**Item No. Report of the Interim Director of Planning, Regeneration & Public Realm****Address** 56 DIAMOND ROAD RUISLIP**Development:** Variation of Condition 2 (Approved plans) and Condition 3 (Materials) of planning permission ref. 16429/APP/2021/1533, dated 11/06/21 (Single storey rear extension) to change wall finishes from render to brick including a window to the flank wall.**LBH Ref Nos:** 16429/APP/2022/1951**Drawing Nos:** 56AA  
56AB**Date Plans received :** 04/07/2022**Date(s) of Amendment(s):****Date Application Valid:** 04/07/2022**1. SUMMARY**

The application seeks permission for a variation of Condition 2 (Approved plans) and Condition 3 (Materials) of planning permission ref. 16429/APP/2021/1533, dated 11/06/21 (Single storey rear extension) to change wall finishes from render to brick including a window to the flank wall.

Drawing no:-56AA

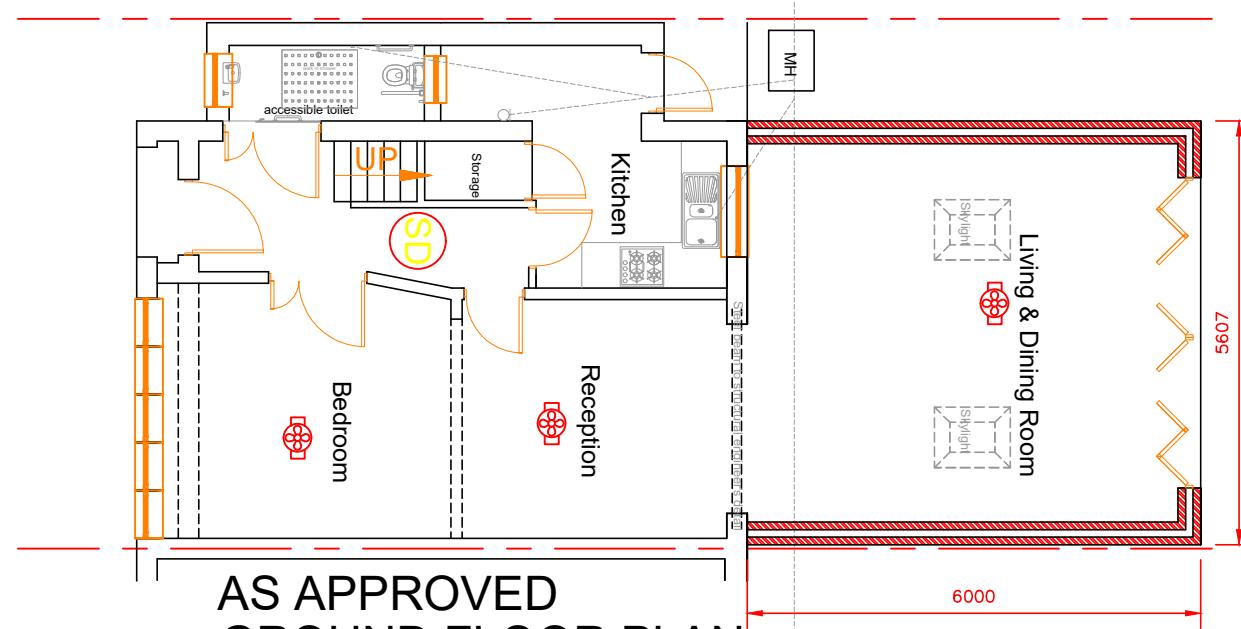
The revised plans do not involve any increase to the scale and massing of the extensions previously approved and as such the application is not considered to give rise to an increased loss of light or outlook to occupants of neighbouring dwellings when compared to the extant, approved permission. The revised scheme does involve the insertion of a side facing ground floor window to the rear extension which is shown on the submitted plans to be obscure glazed. A condition was imposed on the original planning permission to prevent the addition of side facing windows, to ensure the amenity of occupants of neighbouring dwellings are protected. The proposed side facing window facing number 58 is not considered to give rise to an undue loss of privacy given the intervening 1.8m high boundary fence and the obscure glazed nature of the window proposed. It is considered reasonable to impose a condition to ensure that the window is retained as obscure glazed and non opening below 1.7m above FFL. Subject to obscure glazing, this is acceptable.

The kitchen window facing 58 Diamond Road shall be glazed with permanently obscured glass to at least scale 4 on the Pilkington scale and be non-opening below a height of 1.7 metres taken from internal finished floor level for so long as the development remains in existence.

Drawing no:-56AB

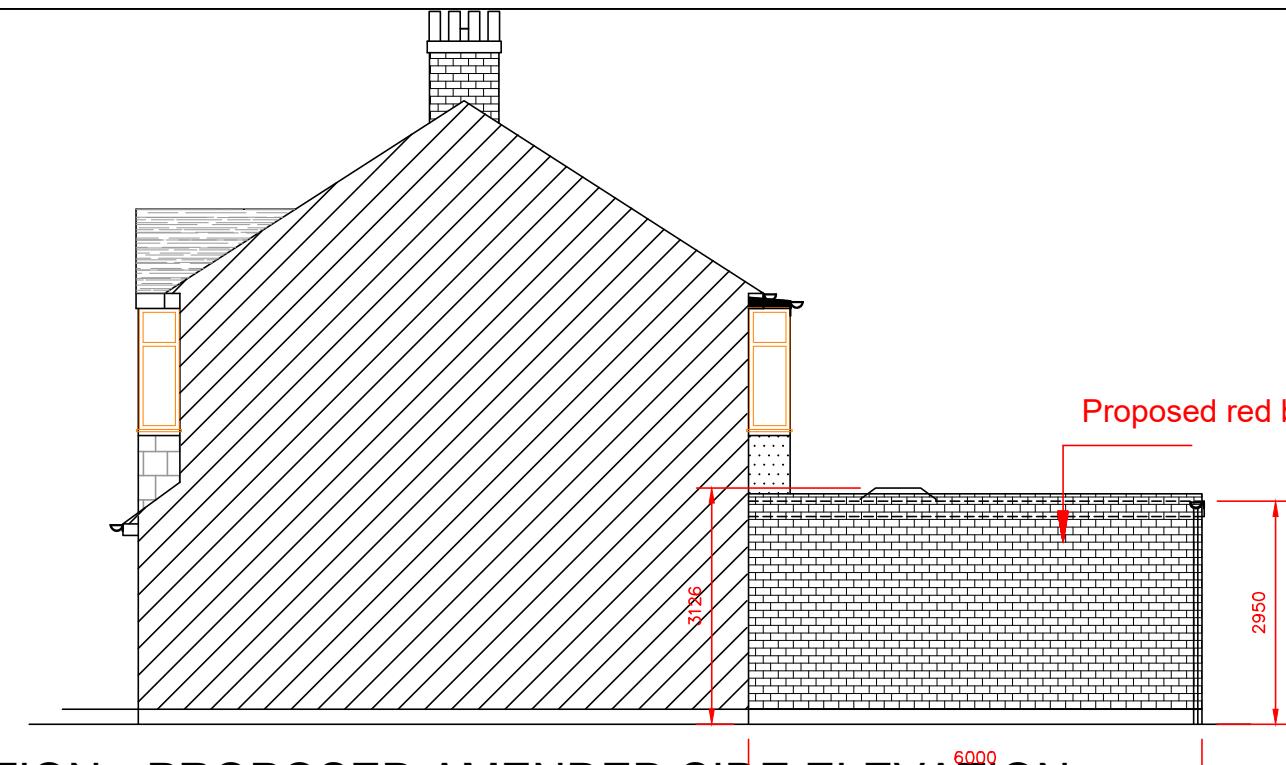
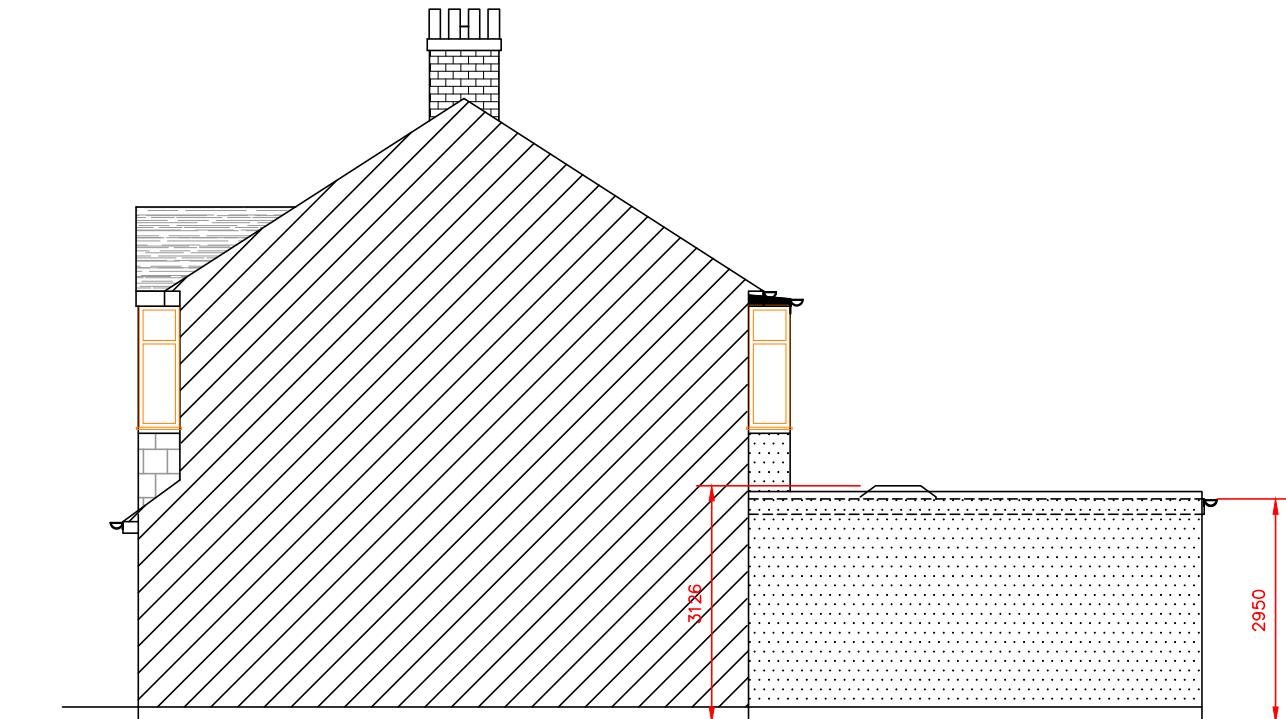
The amendment to the materials is considered acceptable. There is a mixture of red brick and pebble-dash render in the immediate vicinity and the materials used on the extension are considered to relate satisfactorily to the host dwelling and locality.
